**Consultation Response from KC,
Highways Development Management**

**2023/91715 Mohaddis E Azam Education Centre And Masjid E Madani, 225C, Ravenshouse
Road, Dewsbury Moor, Dewsbury, WF13 3QU**

Demolition of existing mosque and erection of mosque and education centre

Date Responded: 11/09/23

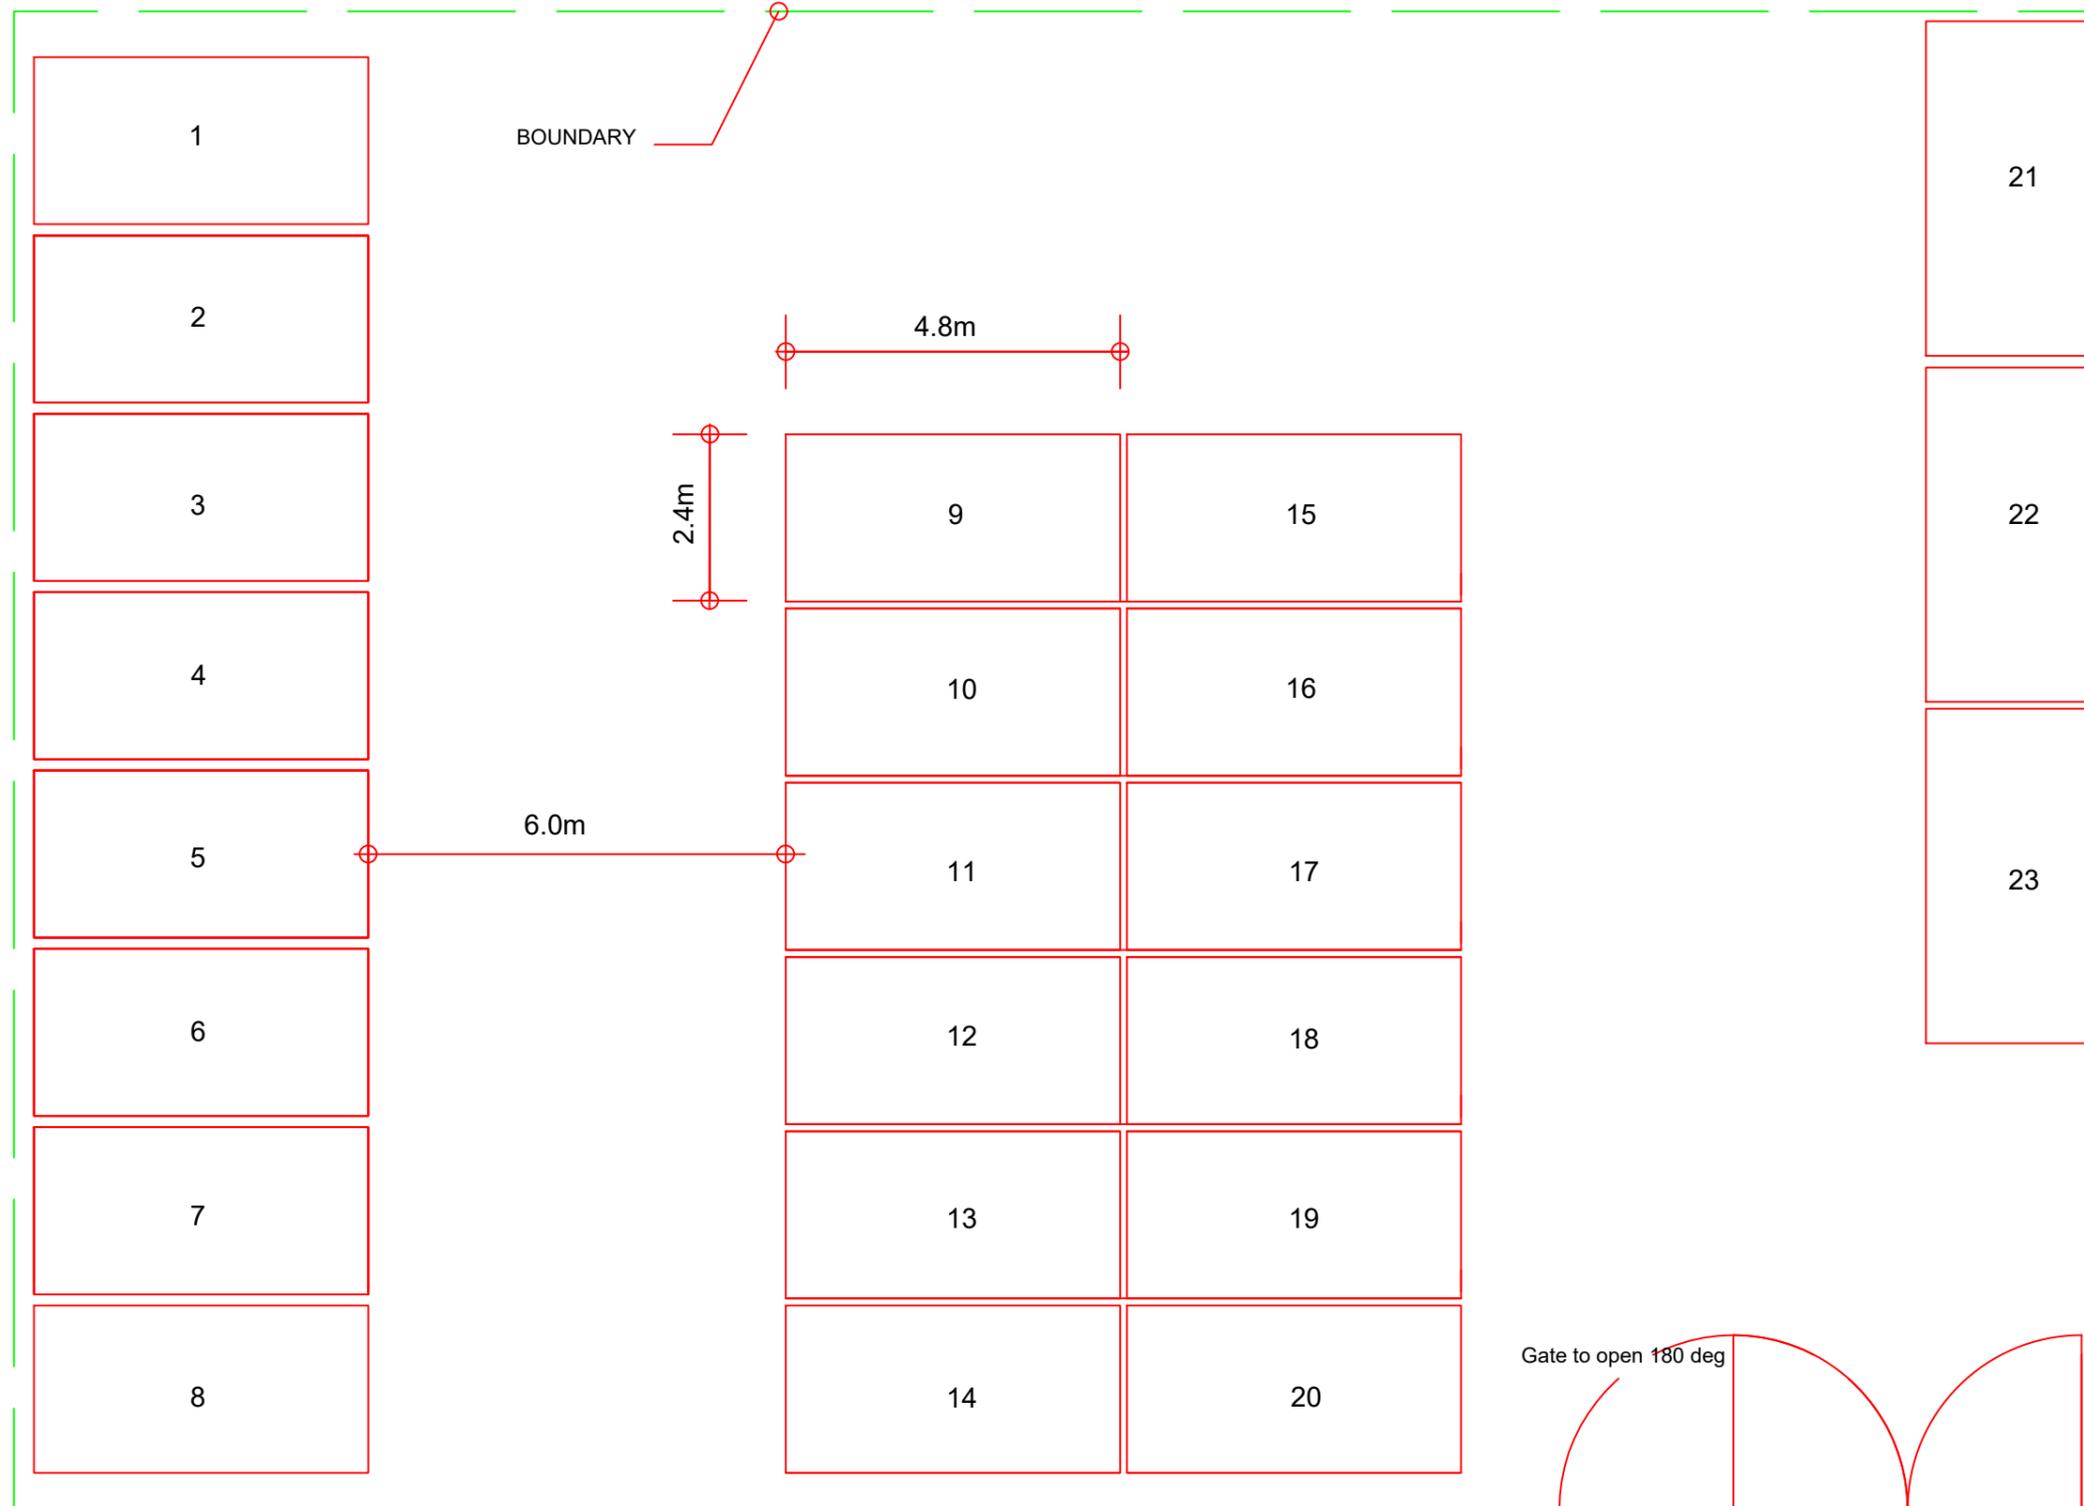
The proposed car park is set out in drawing No AIB/01 Proposed Layout (Sept 2021) and shows a single access with 23 parking spaces, however paragraph 4.6 of the submitted planning statement suggests that there are spaces for 26 cars with two disabled spaces and this is not what is shown on the parking layout drawing. The parking spaces scale to approximately 2.4m x 4.8m with a 6m headway between spaces 1 to 20 to allow cars to manoeuvre safely. Spaces 21 to 23 are tandem against the edge of the car park and don't allow for independent access, ie space 23 would block in the other two spaces and space 22 would block in space 21. This may be suitable for staff parking or use at prayer times if the car park is managed and attendants can stack the cars, this process has been observed in use at other similar land uses, but this would require the use of marshals to control the parking.

Drawing No AIB/01 Proposed Layout (Sept 2021) shows the car park with a single access over a dropped kerb crossing. The site, as constructed, has two gates and two dropped kerb crossings on to Ravenshouse Road and a single vehicle and separate pedestrian access on to the Back Ravenshouse Road. To comply with the proposal drawing we would like to see the second gated access on Ravenshouse Road (to the south) removed and the redundant dropped kerb crossing reinstated to a full kerb with the "H-bar" marking removed, and the vehicular access on to Back Ravenshouse Road removing. These changes should be clearly marked on a drawing and should be conditioned for highway safety reasons if you are minded for approval, and the works done within a s184 legal agreement with the council, with an appropriate footnote included, wording can be provided if required.
